Application Ref:	3/2025/0733			 Ribble Valley Borough Council www.ribblevalley.gov.uk
Date Inspected:	03/03/26	Site Notice:	N/A	
Officer:	LW			
DELEGATED ITEM FILE REPORT:				APPROVAL

Development Description:	Proposed side extension with front and rear dormer roof extension.
Site Address/Location:	41 St Marys Drive, Langho, BB6 8DL.

PROPOSED SITE PLAN
(SCALE 1:500)

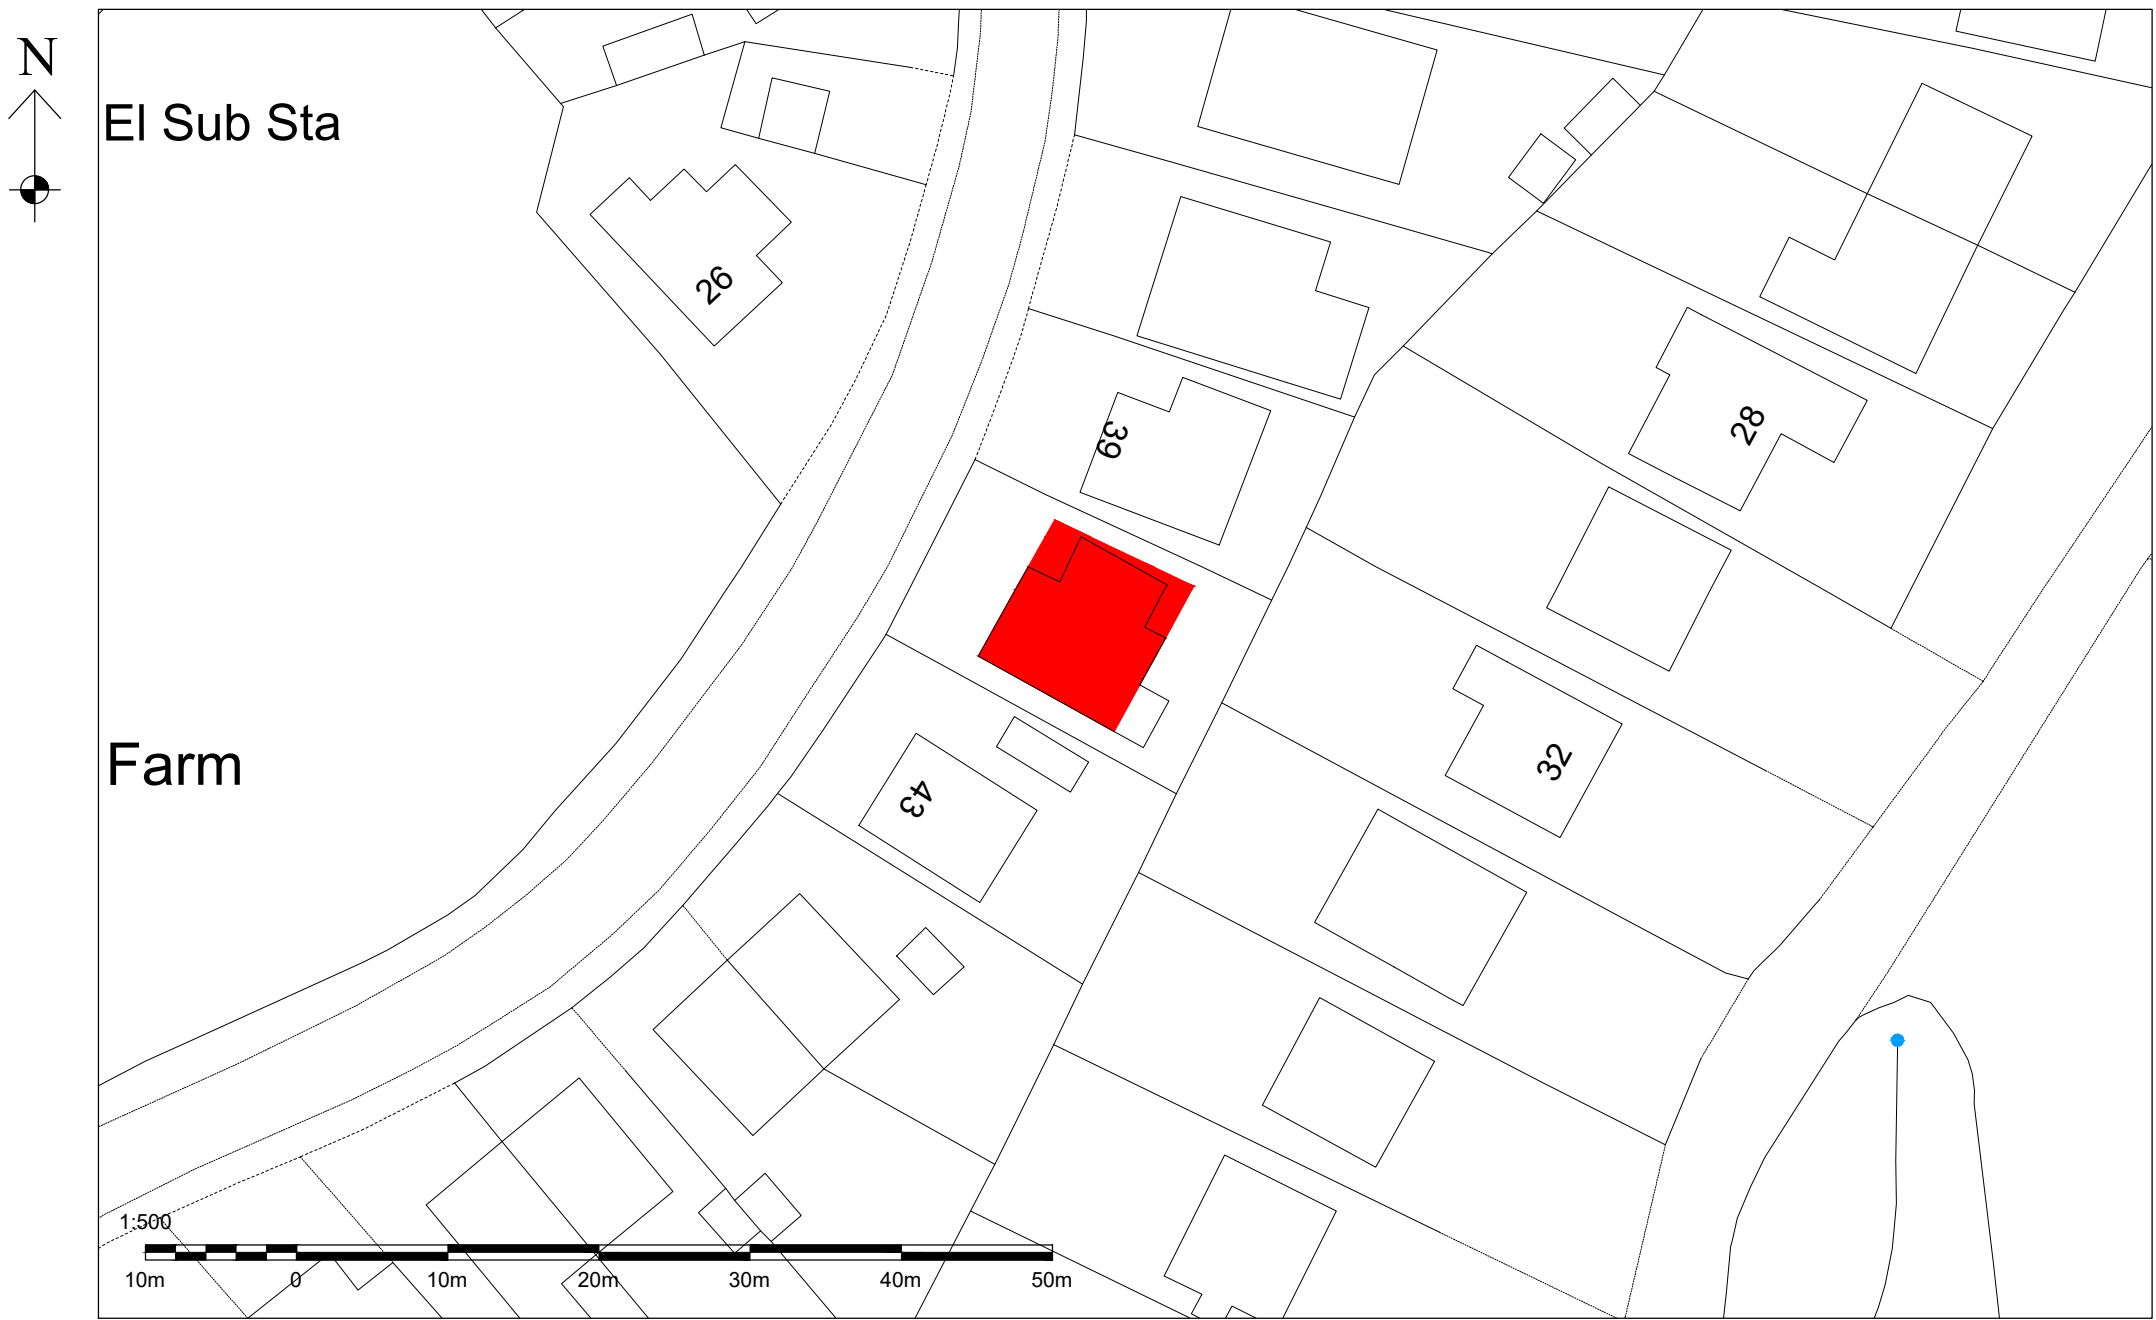
The application has been assessed by Lancashire County Council Highways. In its consultation response dated 12 February, the Local Highway Authority (LHA) noted that the proposed development would result in the loss of the existing garage and increase the number of bedrooms within the dwelling from two to four. Consequently, the LHA advised that a minimum of three off-street parking spaces should be provided to serve the enlarged dwelling.

In response, the applicant submitted an amended site plan demonstrating the provision of three off-street parking spaces within the front curtilage. Following review of the revised layout, the LHA requested that each space measure a minimum of 5 metres in length and 2.4 metres in width to ensure adequate manoeuvring and parking provision in the interests of highway safety.

A further amended site plan has subsequently been submitted, which demonstrates that all proposed parking spaces exceed the minimum dimensions specified by the LHA. The revised plans have been reviewed by the LHA, who have confirmed that they raise no objections to the proposal, subject to the imposition of a condition requiring the driveway to be surfaced in a hard-bound material.

PROPOSED FRONT ELEVATION
(SCALE 1:50)

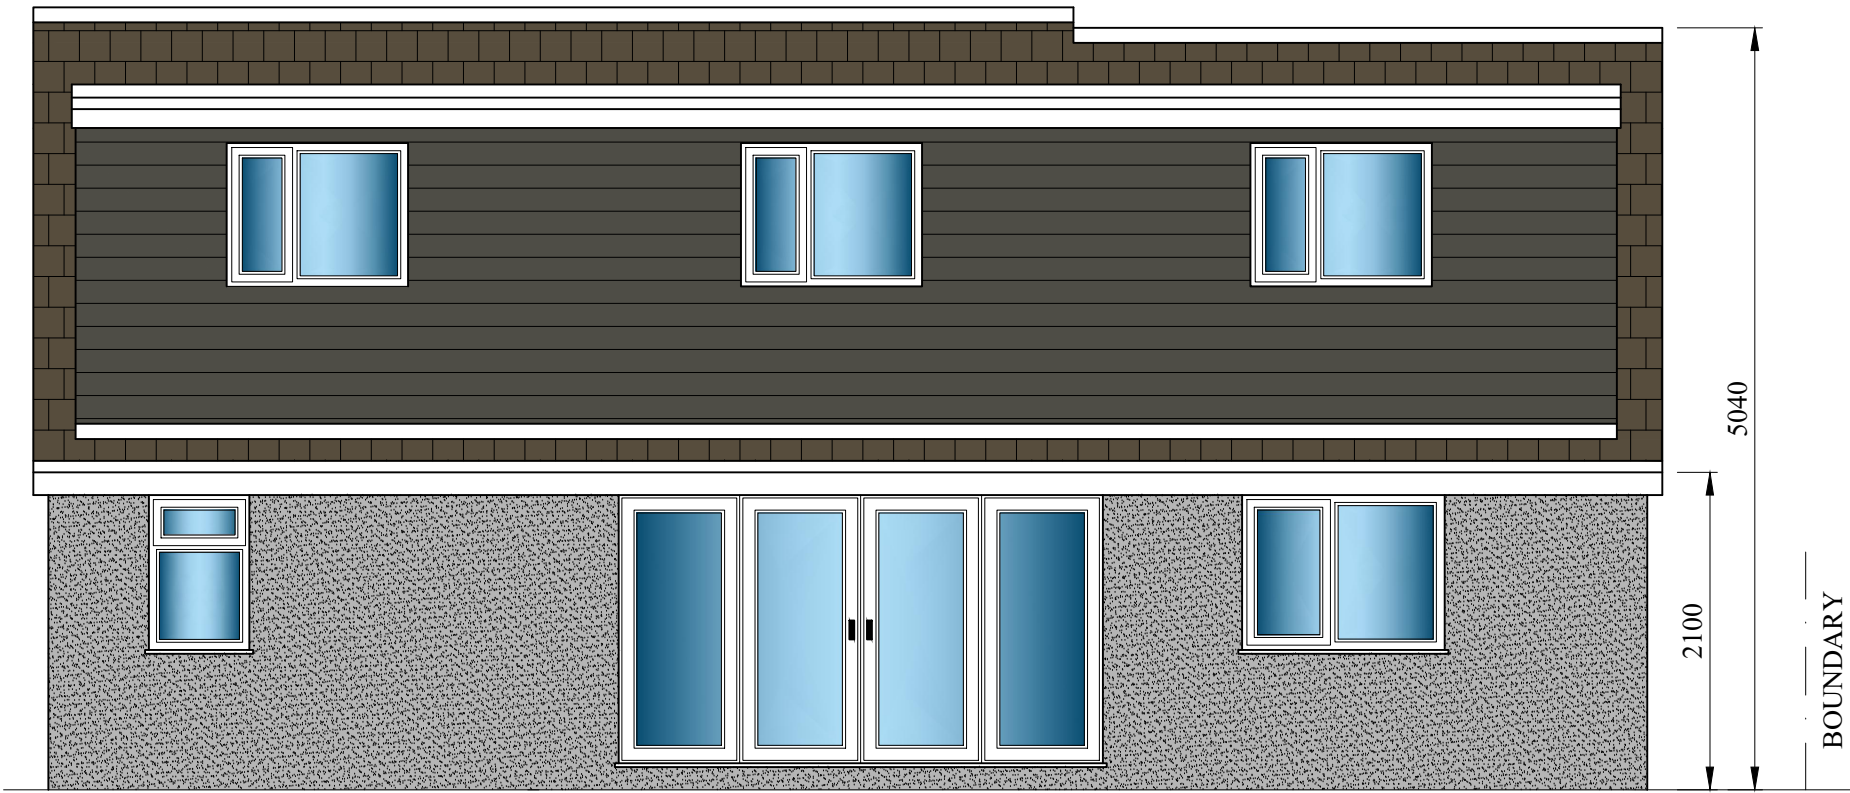
In general, the Local Planning Authority seeks to ensure that two-storey side extensions are appropriately set down from the main ridgeline and set back from principal elevation of the host dwelling. This approach helps to maintain a clear subservient relationship between the extension and the original property, thereby preventing the addition from appearing overly dominant or incongruous. As such, amendments were requested to incorporate both a set-back and set-down to the proposed side extension.

Concerns were also raised regarding the scale and width of the proposed front dormer. Whilst similar in design to the rear dormer, the front-facing element would be significantly more prominent within the street scene. Furthermore, although front dormers are a well-established feature along St Mary's Drive, these are generally confined to the roof slope of the original dwellinghouse. It was therefore considered that the originally proposed front dormer, which extended across both the main dwelling and side extension, would appear unduly wide and incongruous when viewed in the context of the prevailing character and appearance of the surrounding built form.

In response to these concerns, the scheme was amended so that the front dormer is now limited to the roof slope of the original dwellinghouse, with a recessed balcony incorporated within the roof slope of the side extension instead. The revised front dormer is considered acceptable insofar as it reflects the scale and form of comparable dormer extensions present on neighbouring properties. Similarly, the proposed recessed balcony reflects a feature already implemented as part of the two-storey side extension at No. 53 St Mary's Drive. Having regard to these comparable developments, both elements of the proposal are considered, on balance, to be acceptable.
